Our Ref: RR/Haverhill NMA
Your Ref: DC/21/1383/FUL

**RE: Non-Material Amendment Application – Pursuant to planning permission
DC/21/1383/FUL.**

Site: Former Social Services, Camps Road, Haverhill, Suffolk, CB9 8HF.

Drawing Title
Second Floor Plan

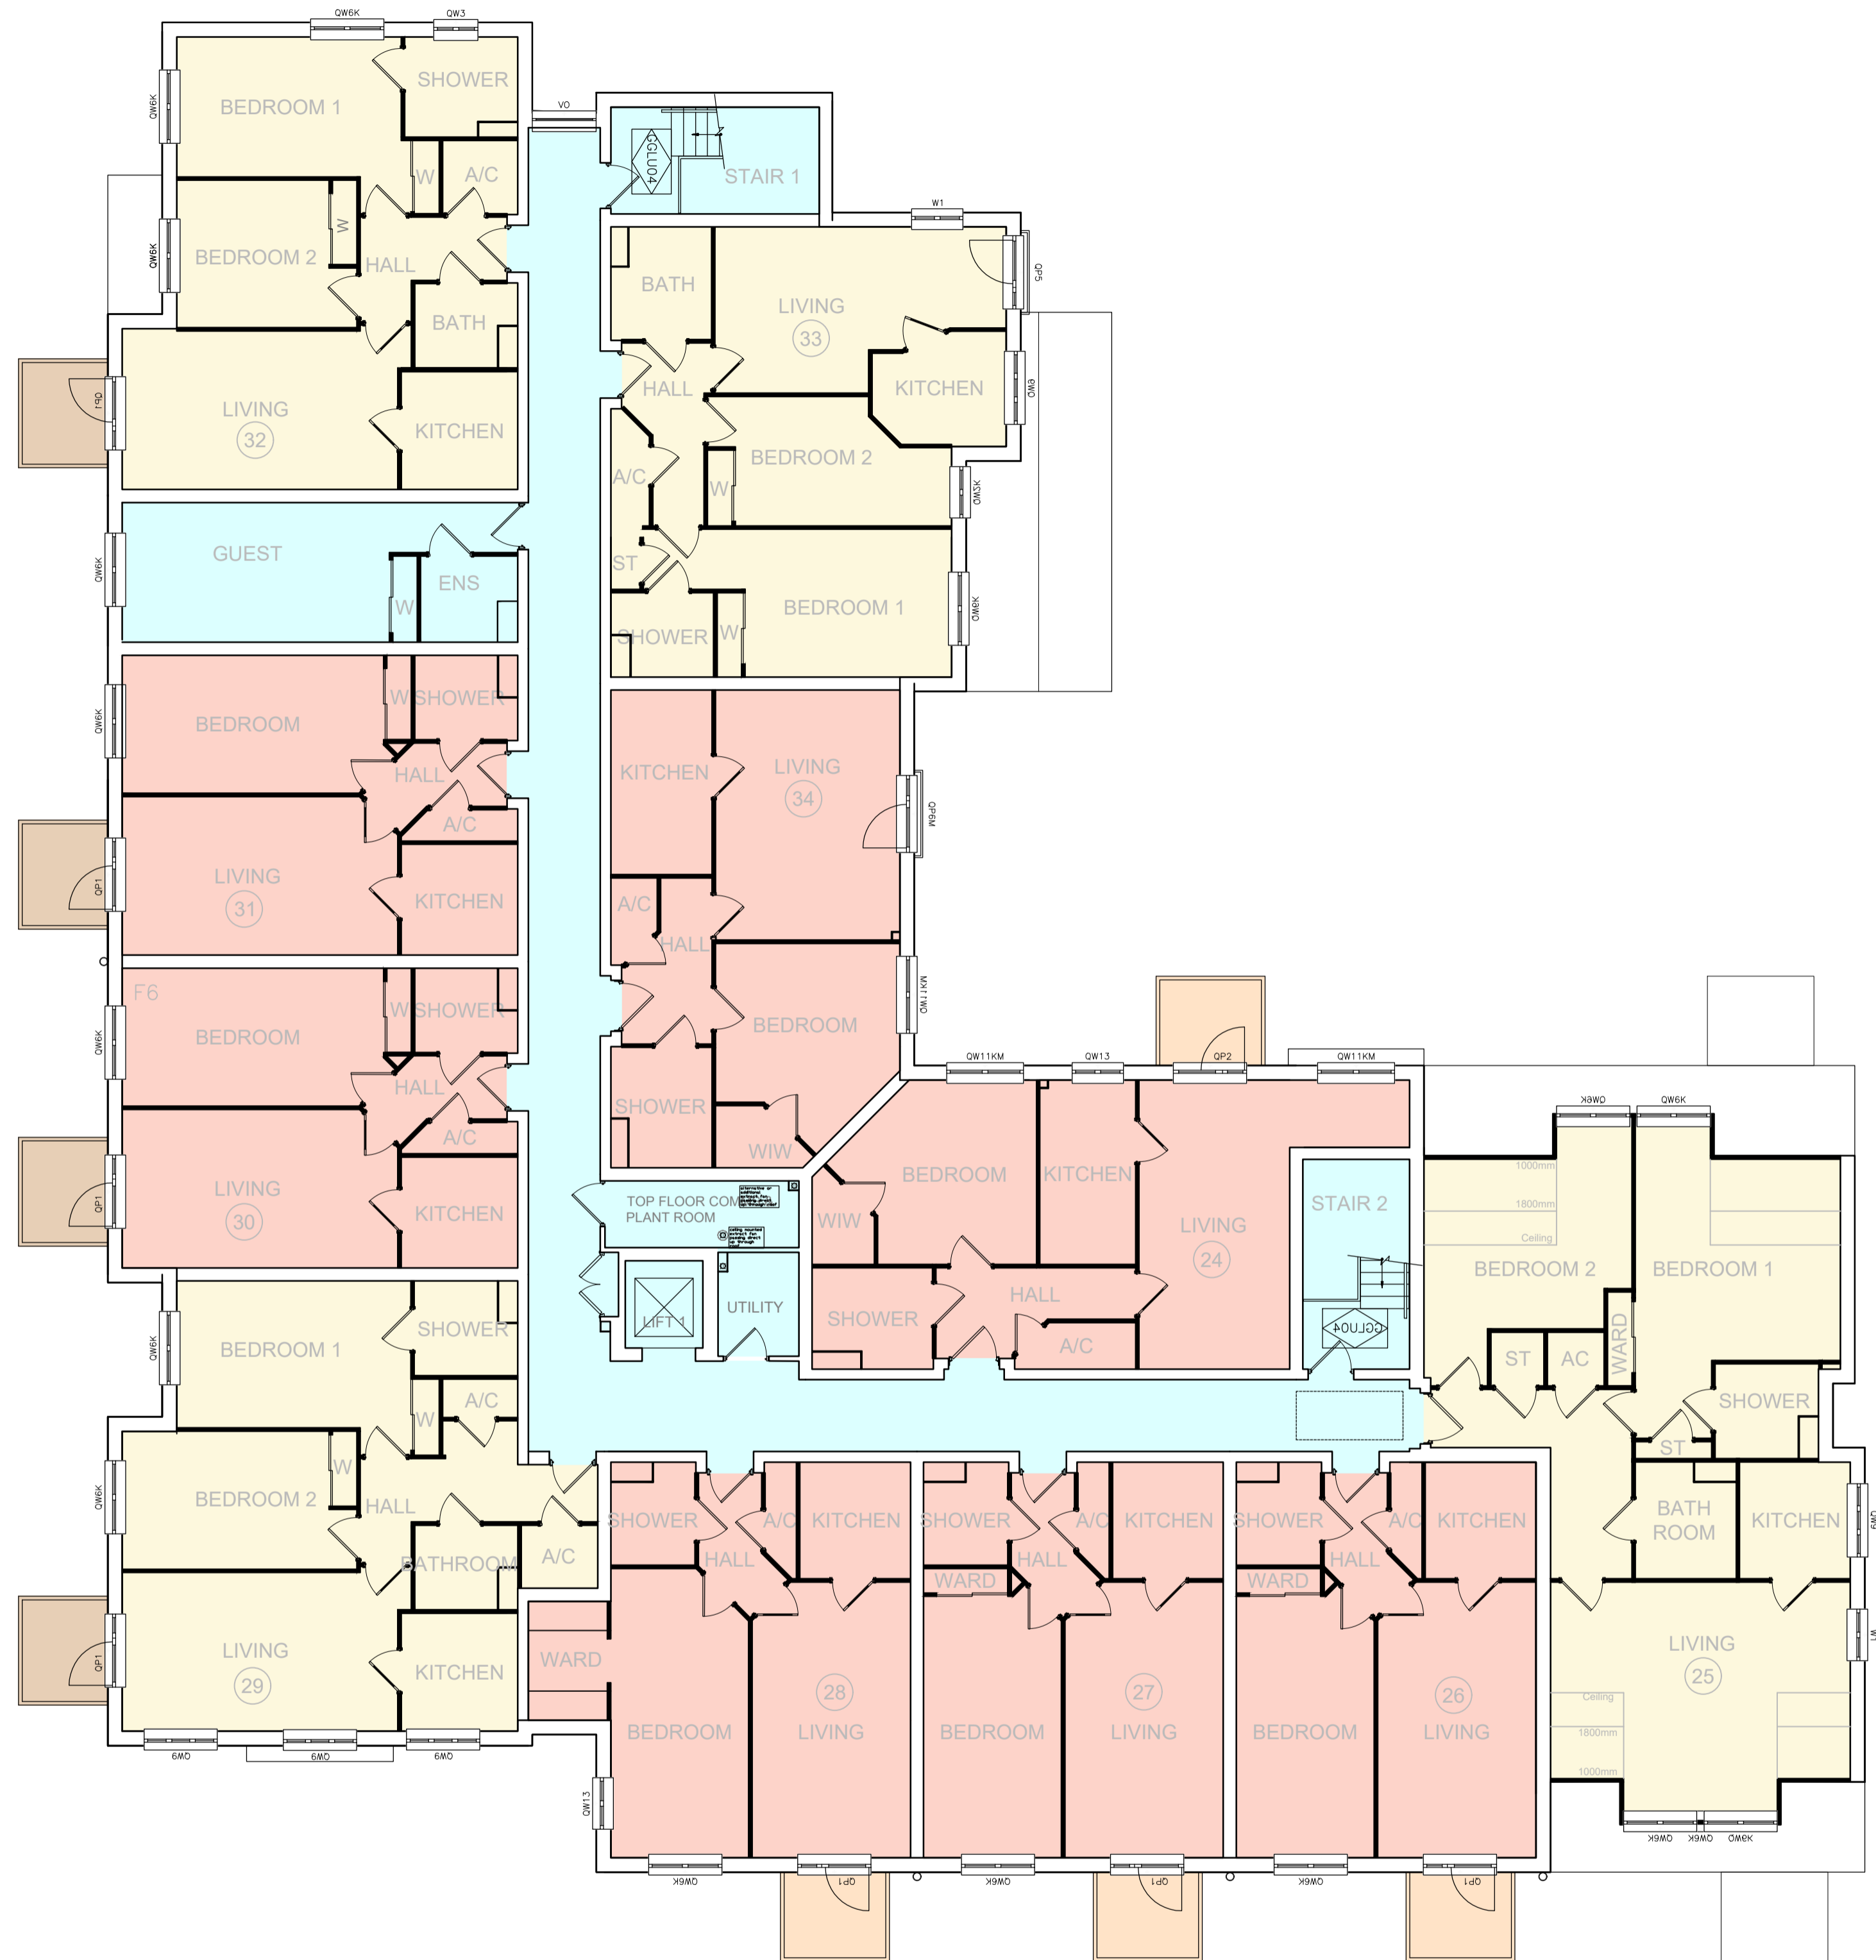
The application seeks to replace eight Juliette balconies with full balconies on the western elevation, facing the access road and Weavers Lodge. This is four at first floor level and four at second floor. These would tie in with the balconies on the front elevation facing Camps Road. Everything else remains as approved under DC/21/1383/FUL and NMA(A)/21/1383 and NMA(B)/21/1383.
